ENG-CDR19004-R2-CD-RD-Redlines .pdf Markup Summary

Subject: Text Box
Page Index: 1
Date: 7/15/2020 5:35:16 PM
Author: dsdrice
Color: ■
Layer:
Space:
Page Label: [1] 1 COVER SHEET

**MERIDIAN ROAD STREET
 IMPROVEMENT PLAN**

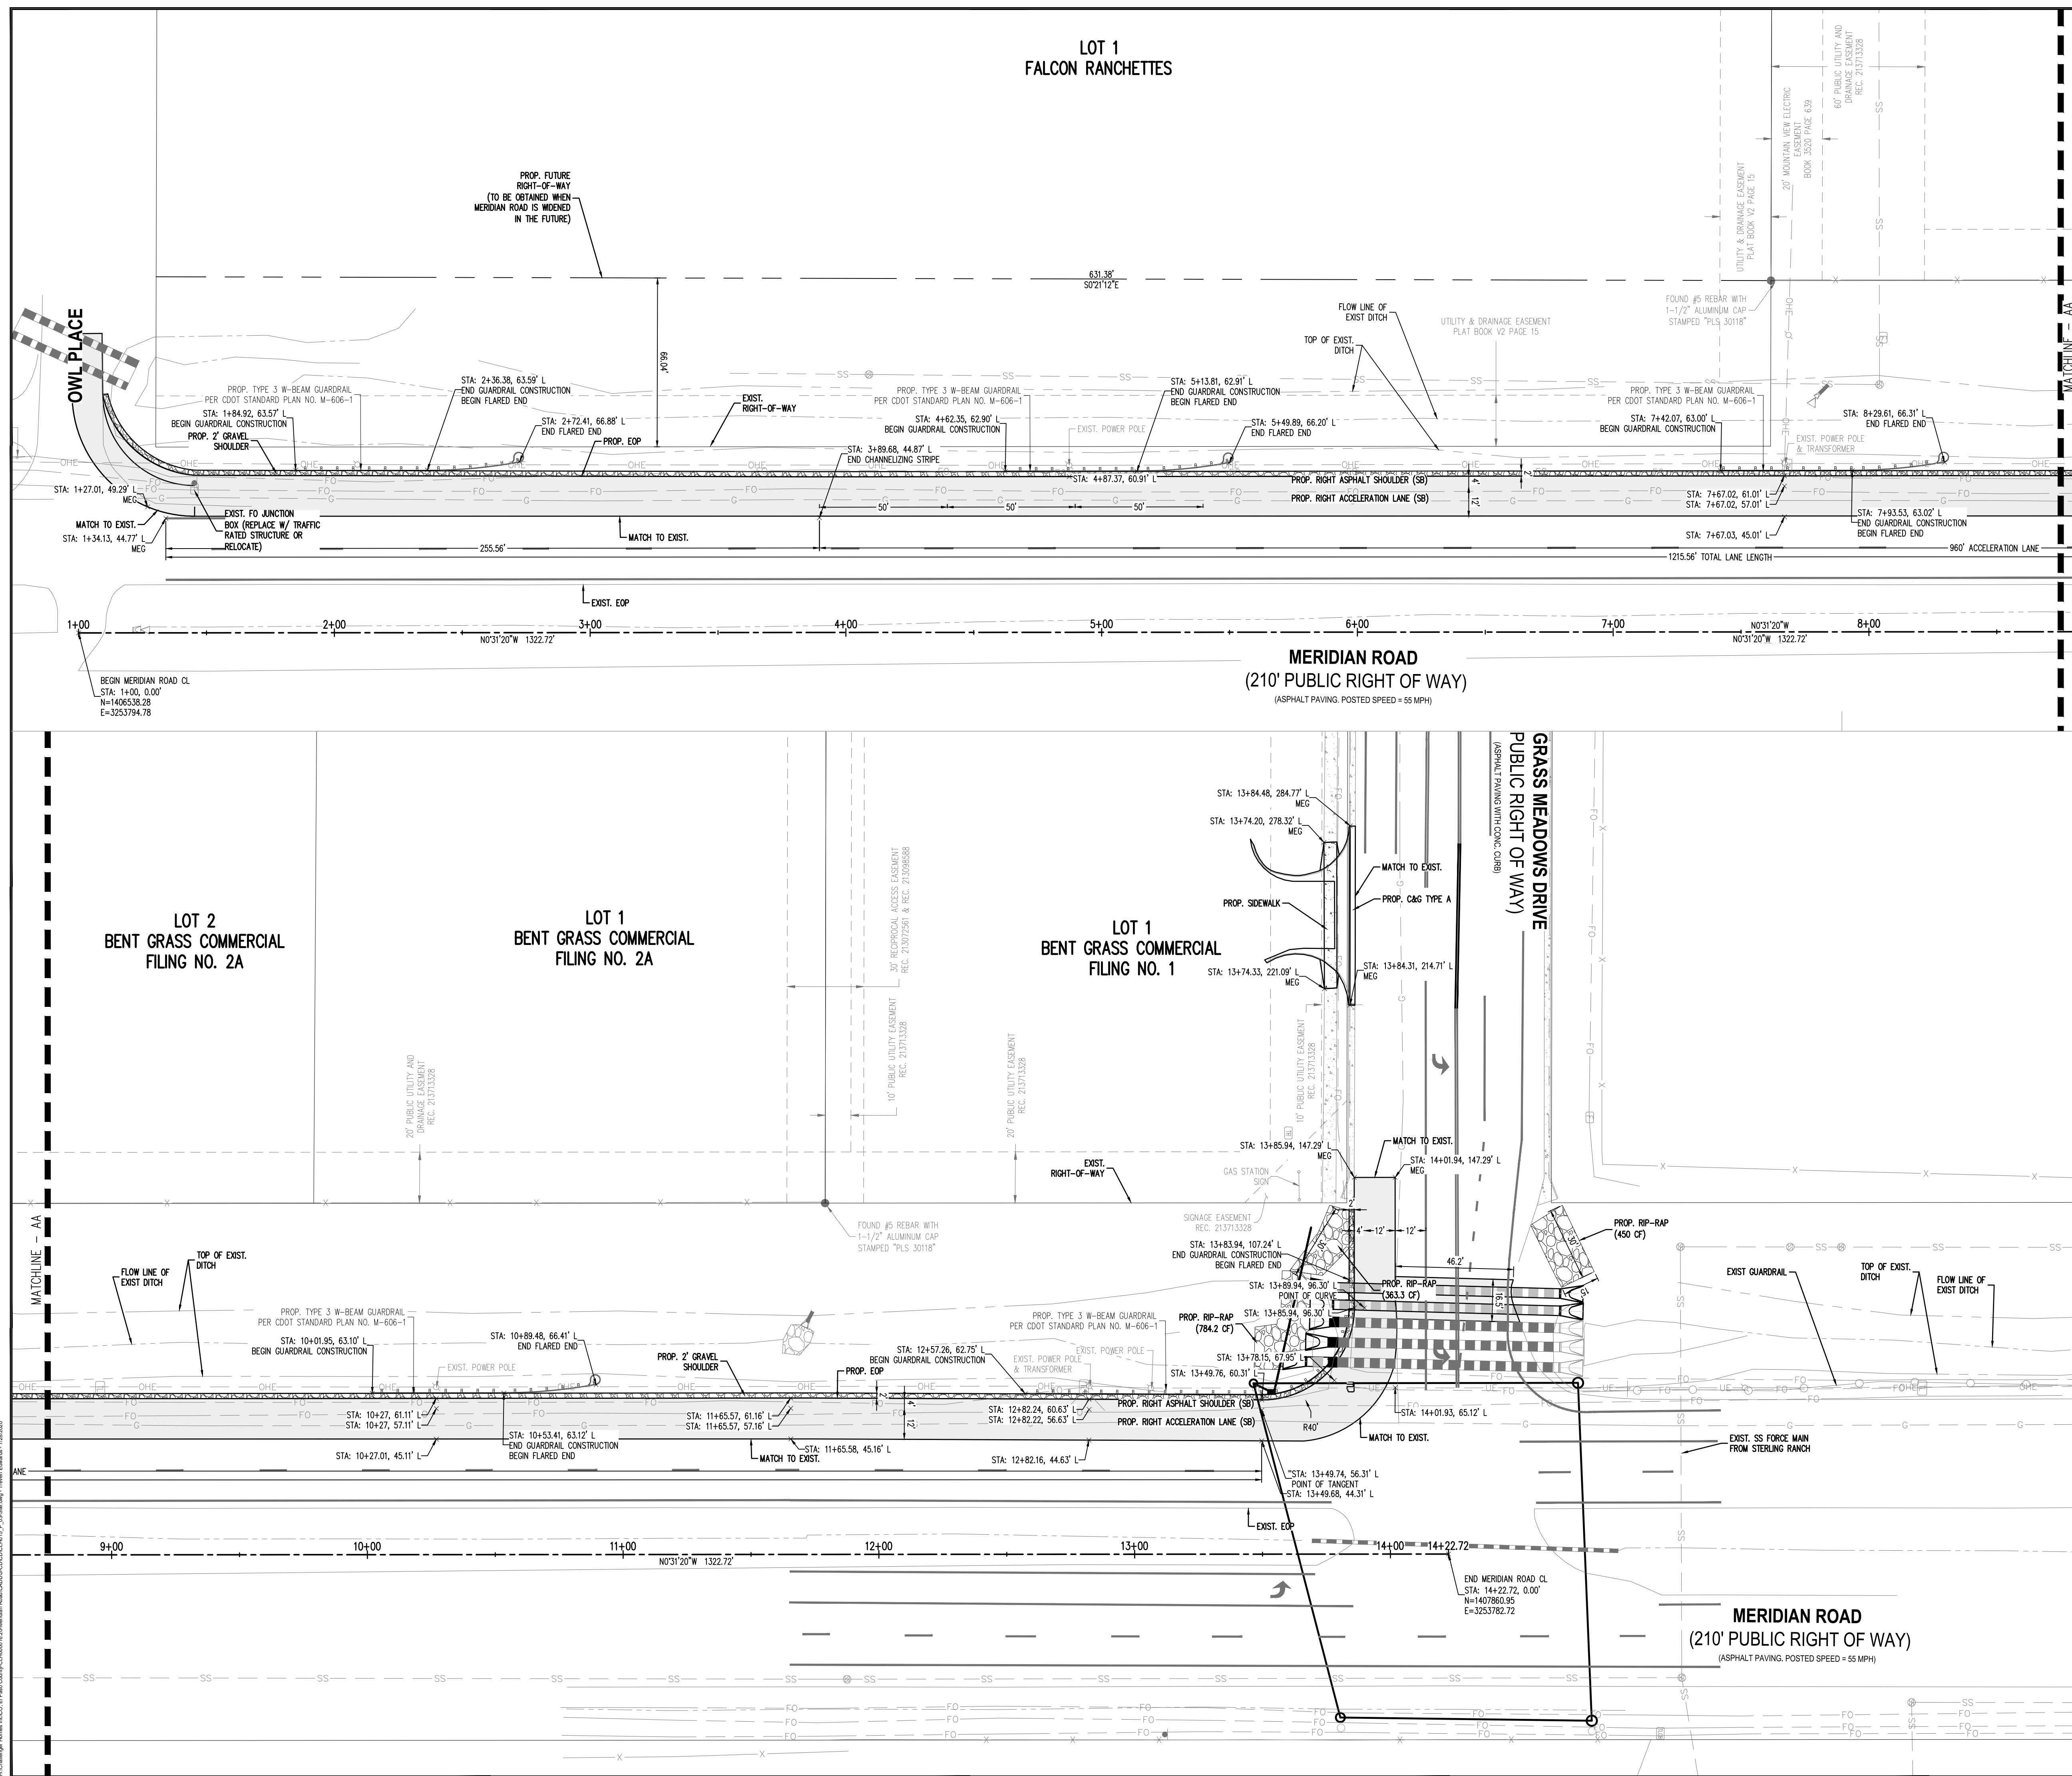
pole conflict with guardrail?

pole conflict with FO?

relocate pedestal?

Does the pole conflict with electric and FO?
 (Where is electric underground now?)

show existing guardrail

MERIDIAN ROAD TYPICAL SECTIONS

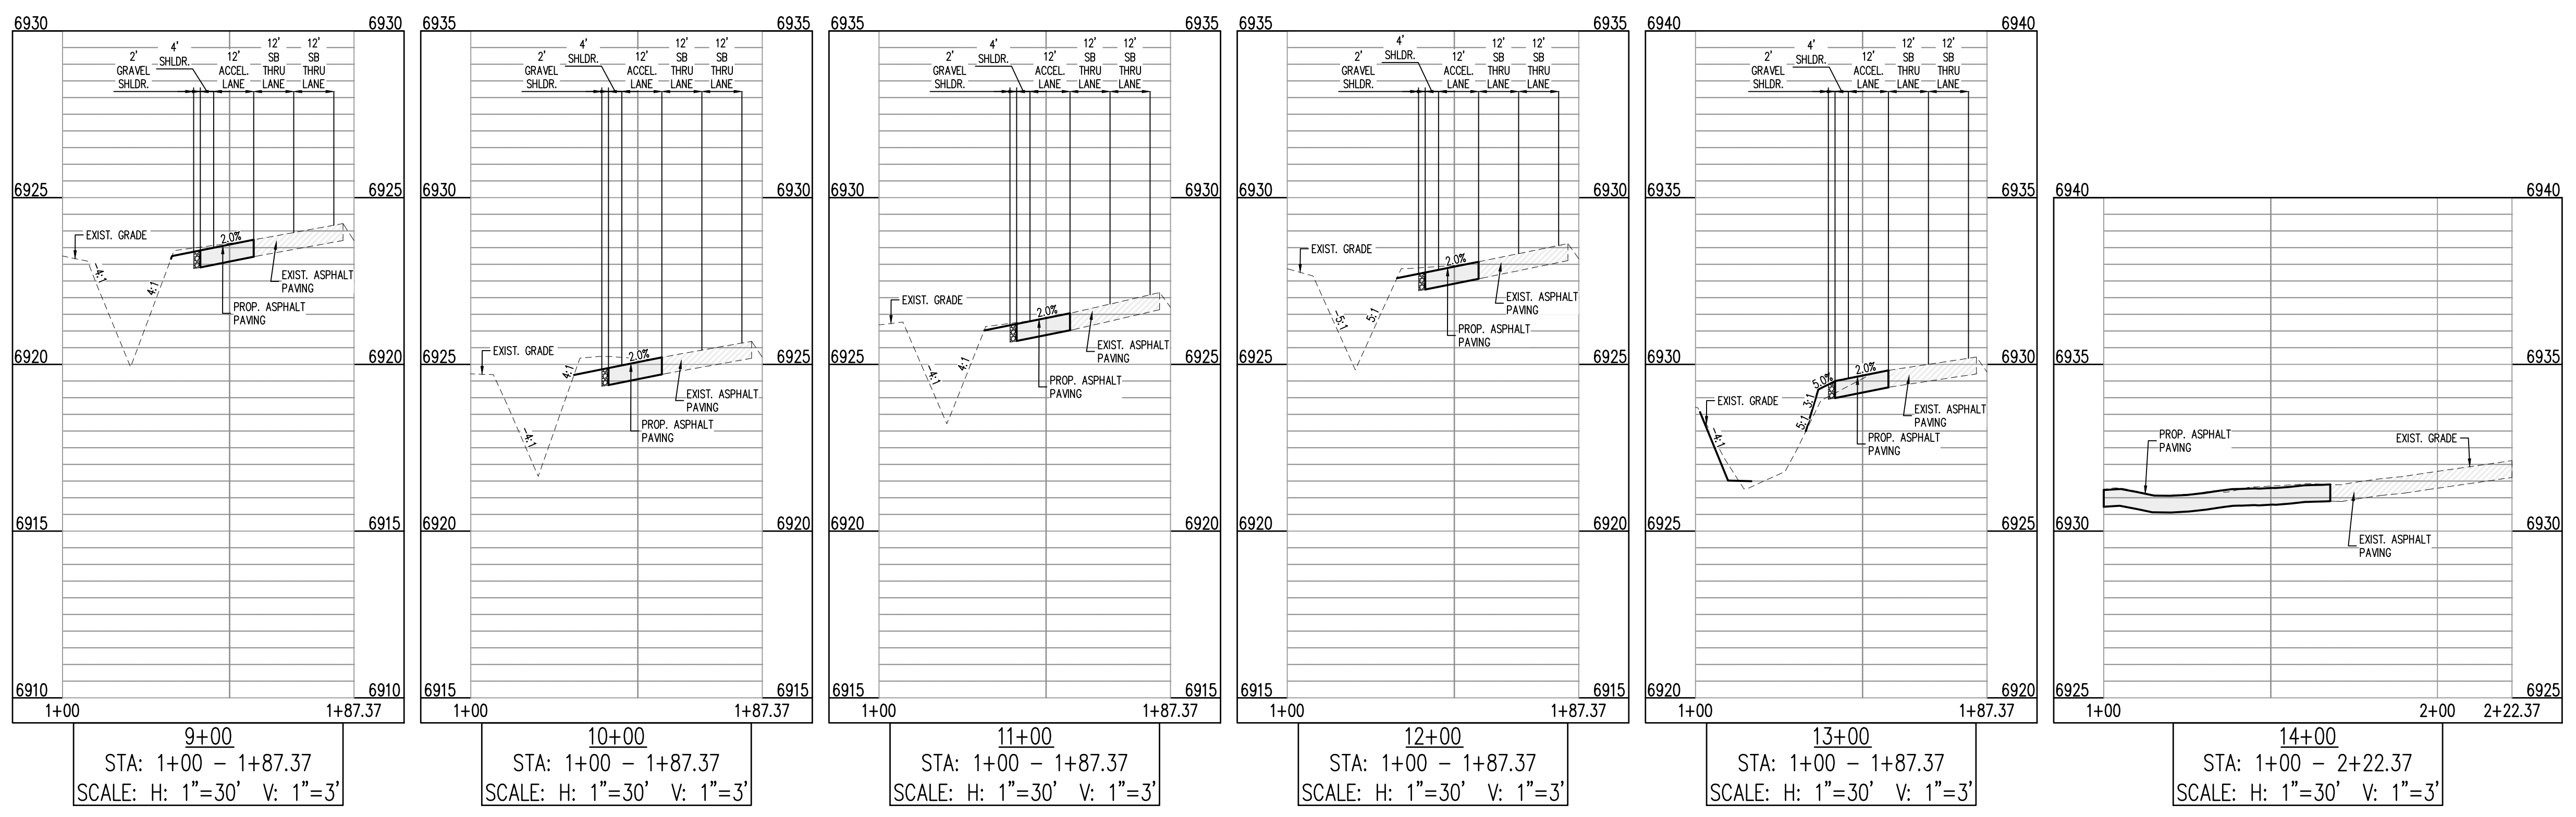
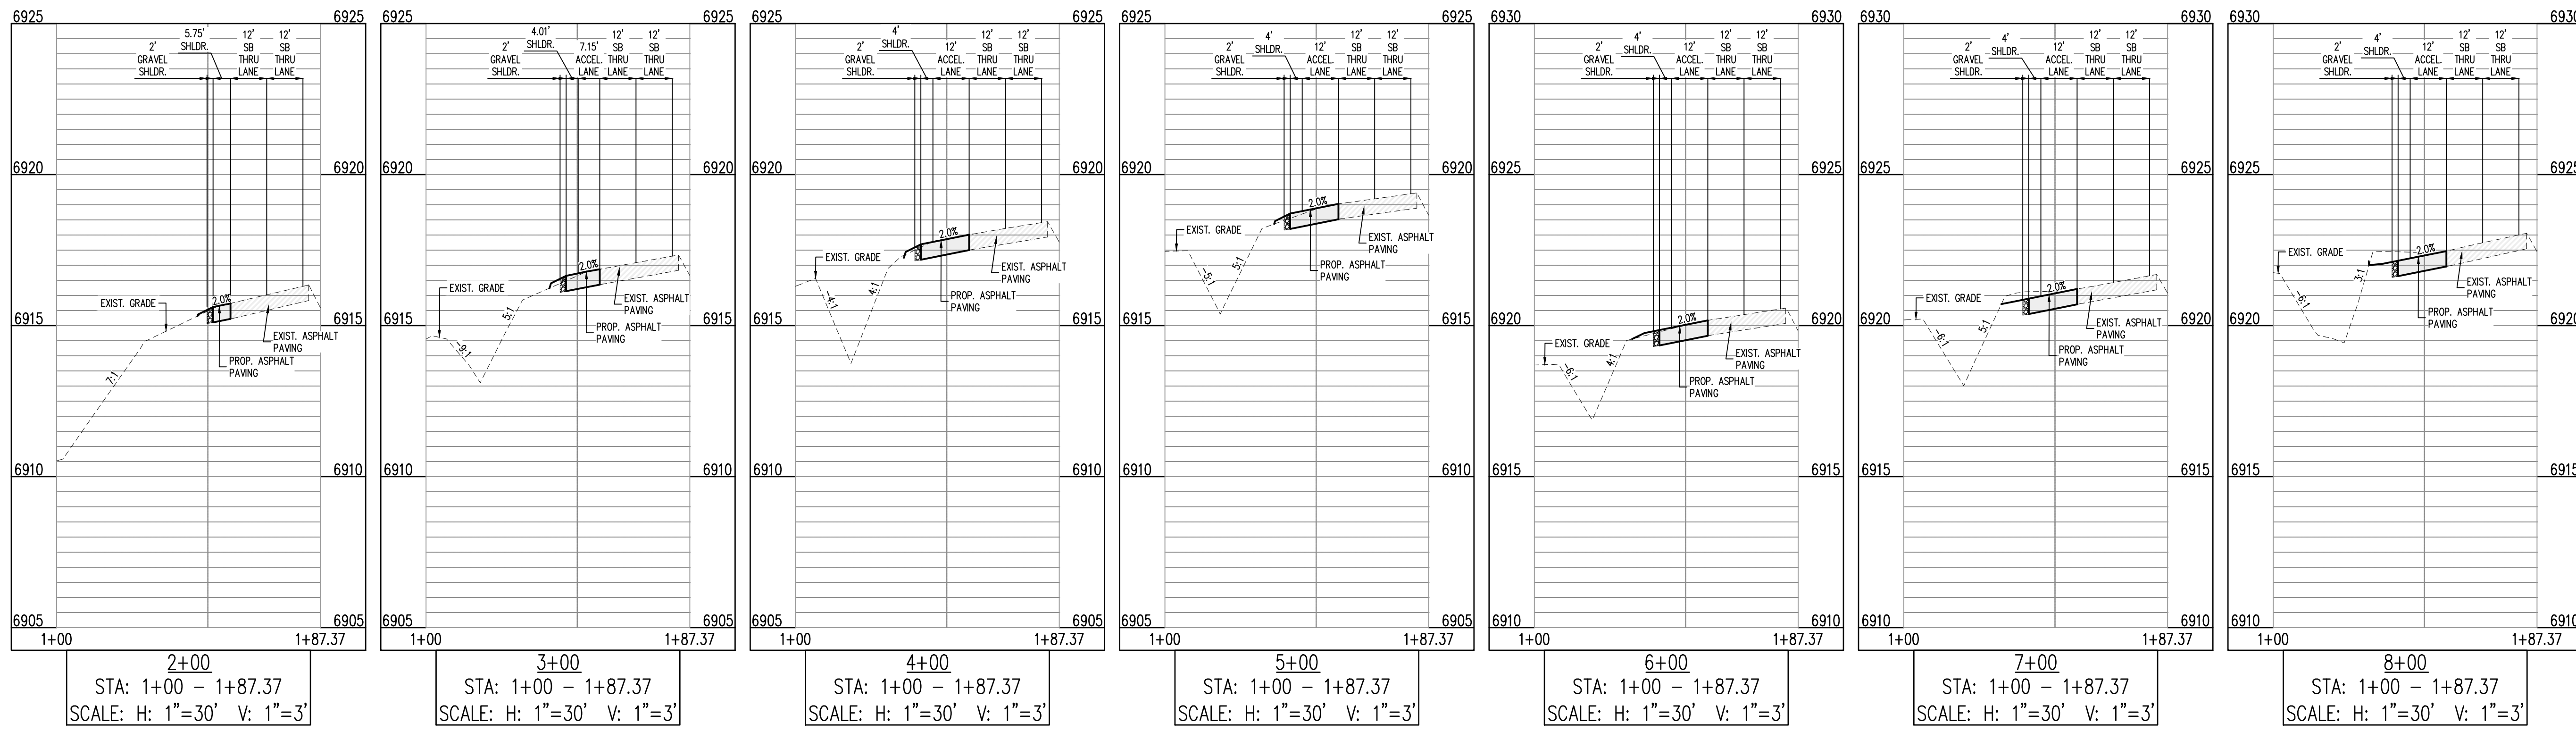
Show and label riprap apron

Sterling Ranch now has a sanitary force main approved crossing here (see GEC Plan in this file: <https://epcdevplanreview.com/Public/ProjectDetails/100141>)

Show and label riprap apron

Show HGL and label design Q

delete arrows

Add right lane must turn right signs

show stop bars

Label all ditch foreslopes and backslopes.
